Fire Marshal Division

**Re: Harnett County Government Center
455 McKinney Pkwy.
Lillington, NC 27546**

Re: Application Number – FMFW2006-0003

Fire Alarm System Plan Review Notes:

1 FIRST FLOOR FIRE ALARM PLAN
 FA-2 Scale: 1/8" = 1'-0"

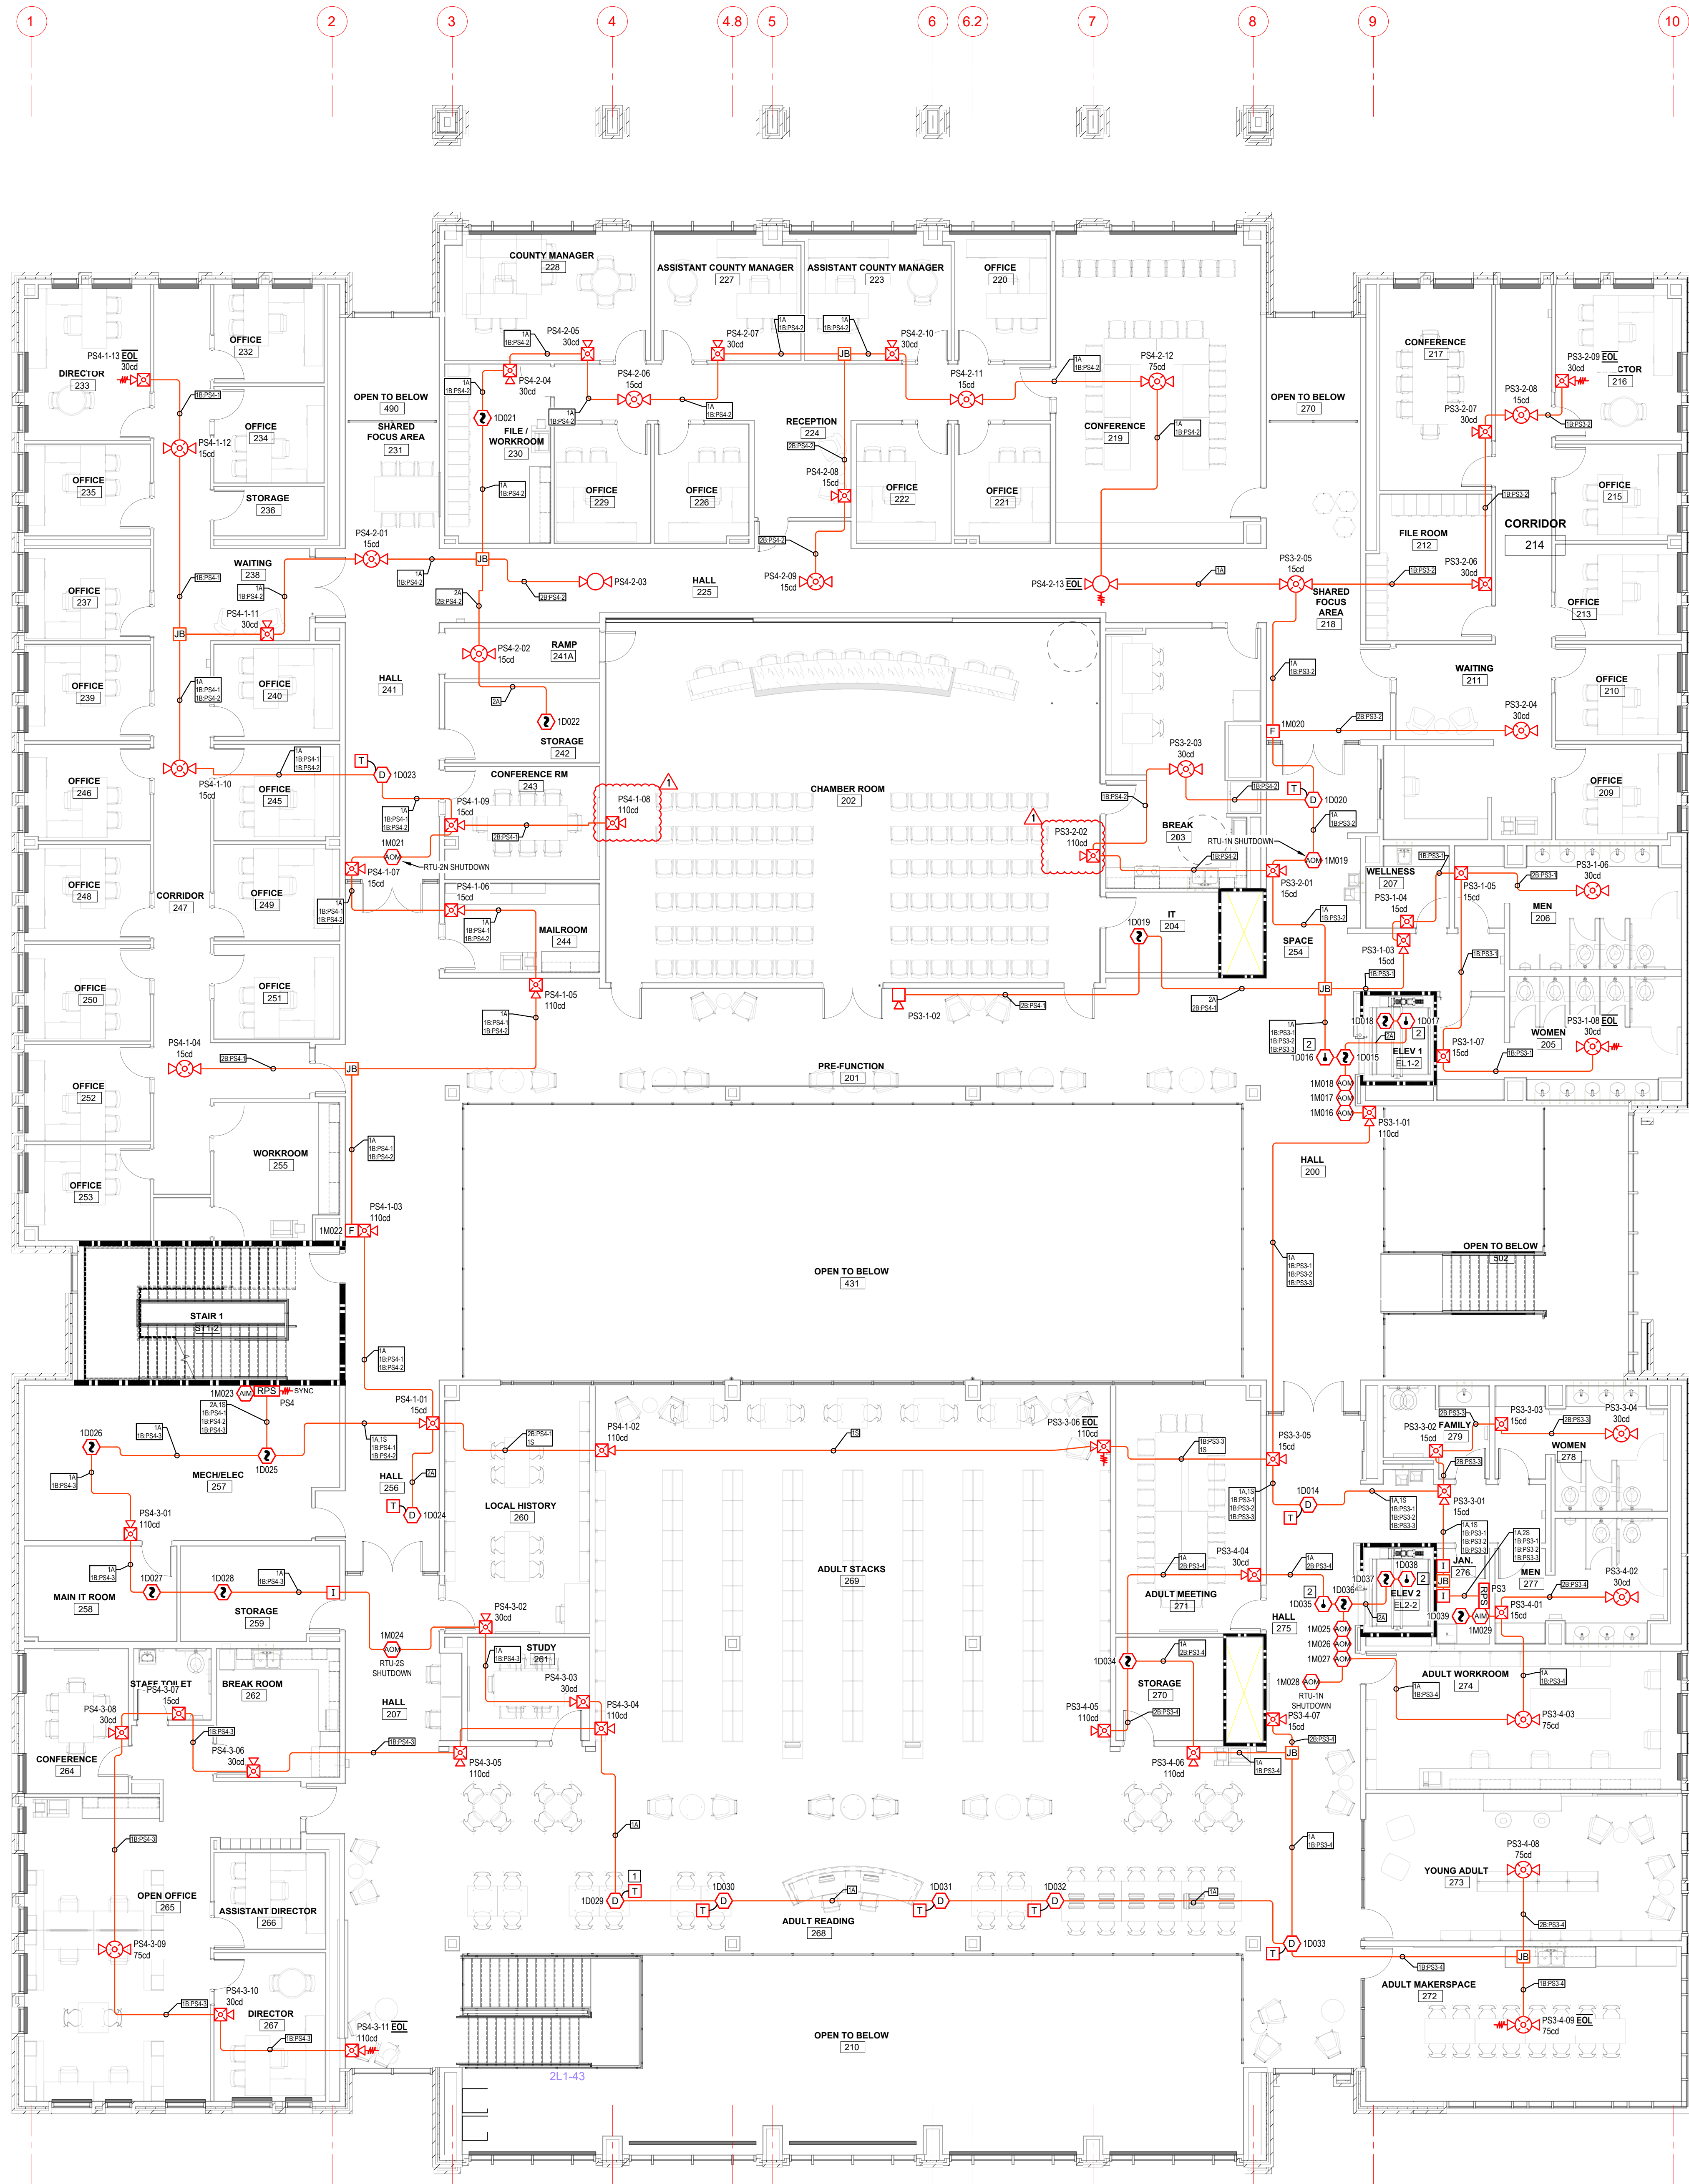
- **Public and common areas**
 - Visible alarm notification appliances shall be provided in public areas and common areas.
 - Notification devices required in meeting room and conference room.
 - Sound pressures shall comply with 907.6.2.1.1 – 907.6.2.1.2 of the NCFPC, current edition.

- Provide coverage for the second floor flex space as covered on the first floor to provide early notification since the space will not be initially occupied.
- Provide a record of completion.
